Application No: FG/72/26/HH
Site Address: 160 Littlehampton Road Ferring BN12 6PH
Description of works: Proposed detached triple garage and extended driveway.

Thank you for your internet representation made on 28th August 2026 which has been recorded as an objection with the comments as follows:

OWPC86251

PROPOSED BLOCK PLAN

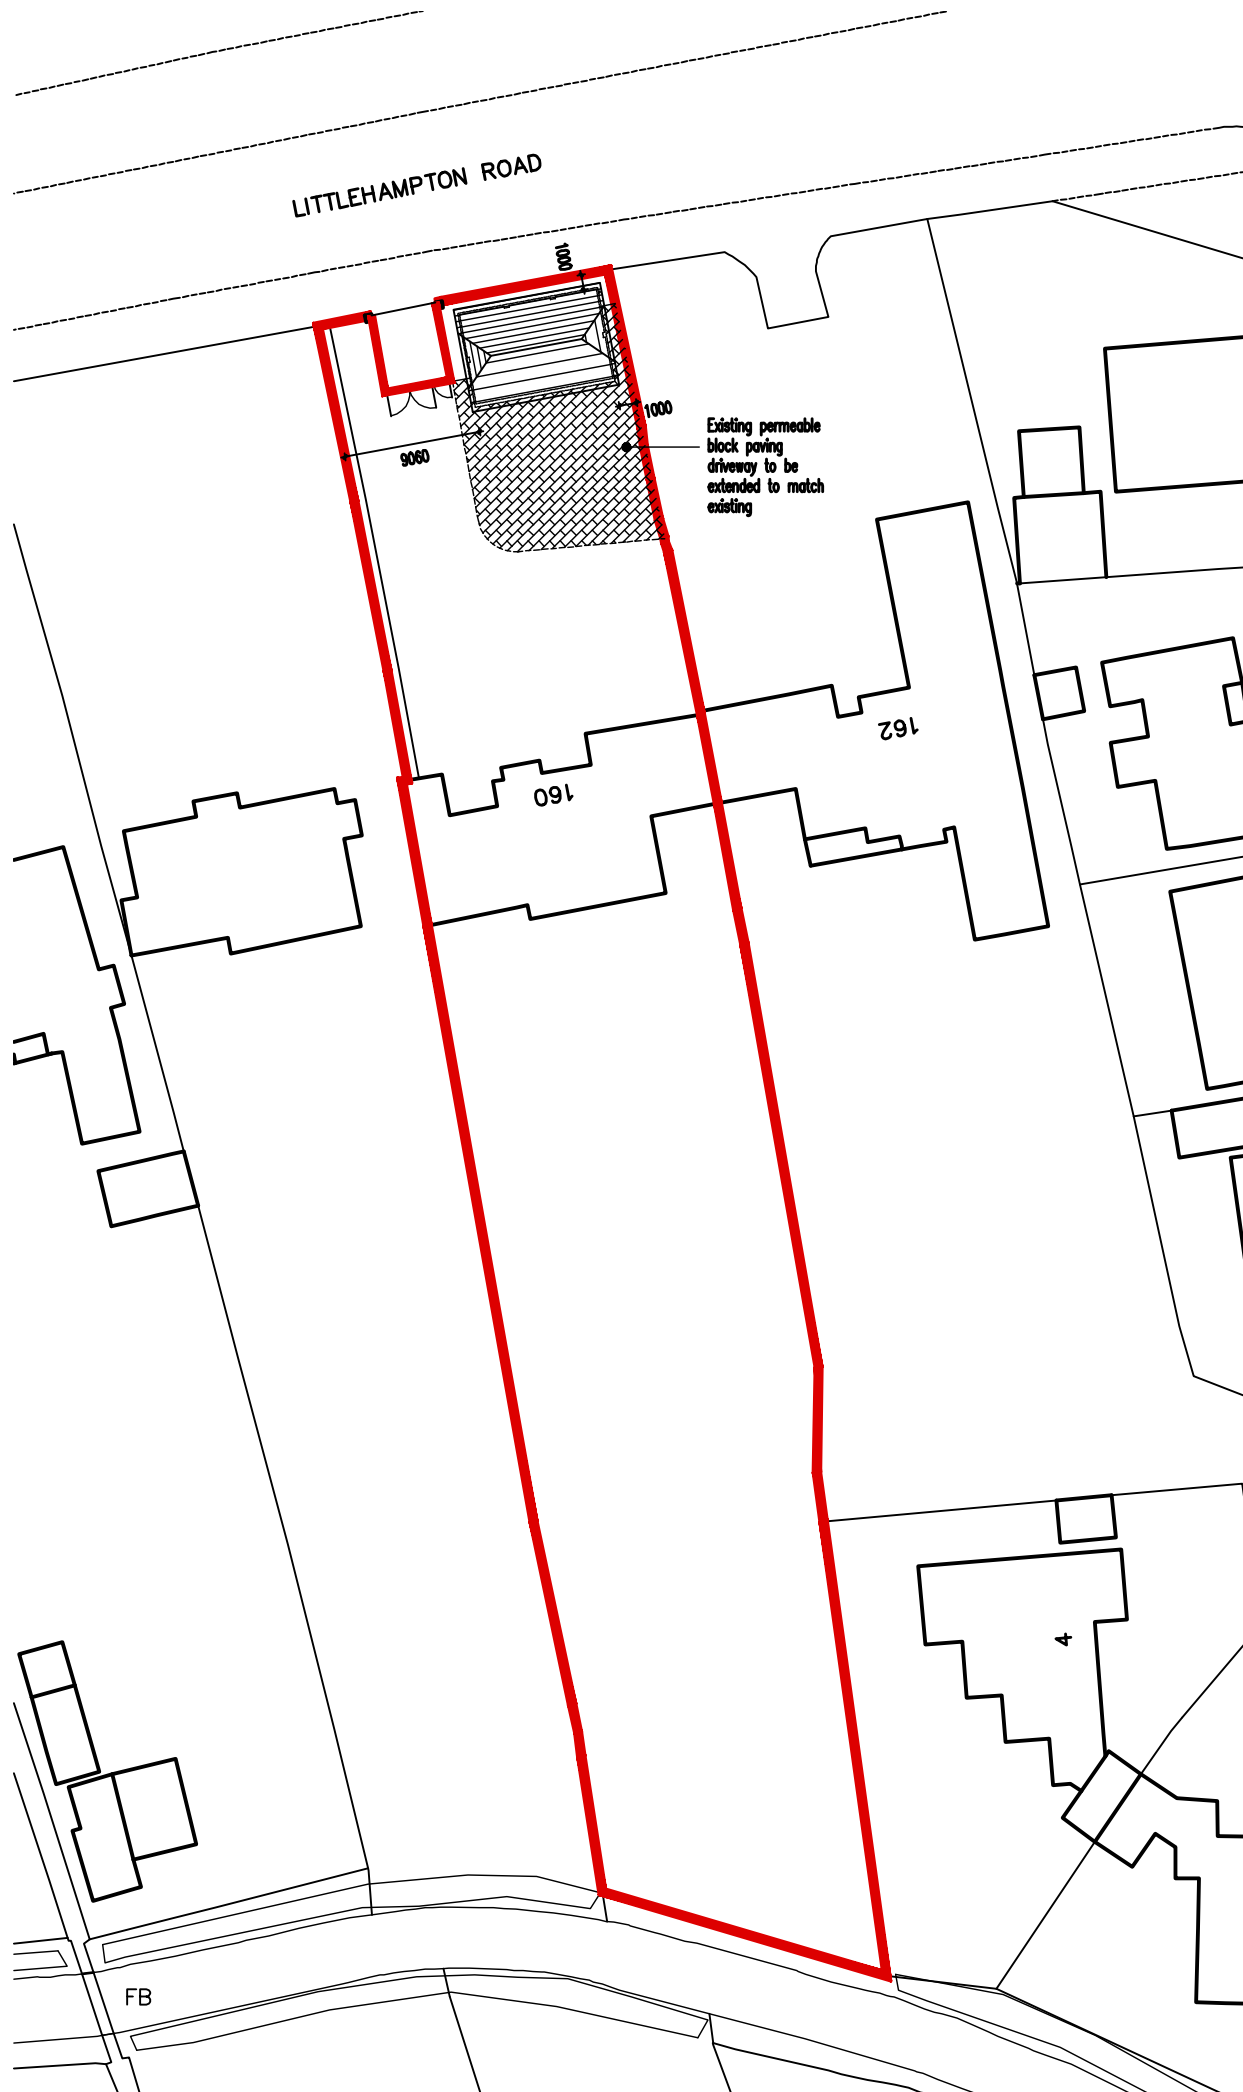
The proposed garage would be positioned only 1 metre from the front boundary. Given its substantial footprint and steeply pitched roof, its height and scale would make it visually prominent and create an obtrusive feature within the street scene.

The Parish Council also notes that there are no other garages associated with nearby properties that are positioned so close to the front boundary. Even more recently constructed garages in the vicinity are set further back from the boundary and have a lower roof pitch, resulting in a less prominent appearance.

FRONT SOUTH ELEVATION
PROPOSED ELEVATIONS
Scale 1:100

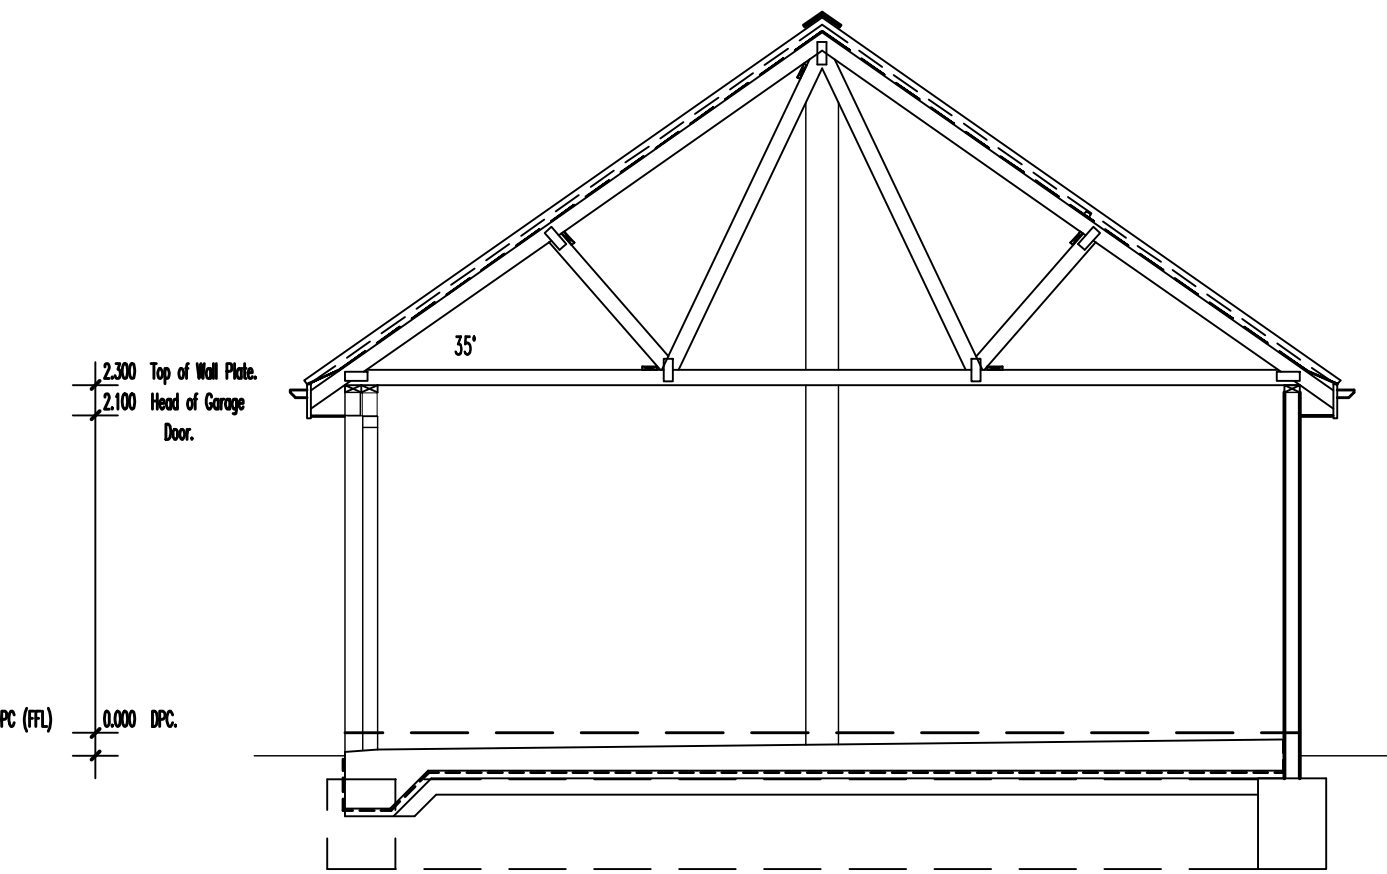
Ferring Parish Council objects to this application on the grounds that the proposed garage, due to its size, height and proximity to the front boundary, would be unduly dominant and have a harmful impact on the character of the street scene.

The proposal would compromise the existing spatial character of the area and, by virtue of its scale, height and siting, would appear unduly dominant when viewed from the road.
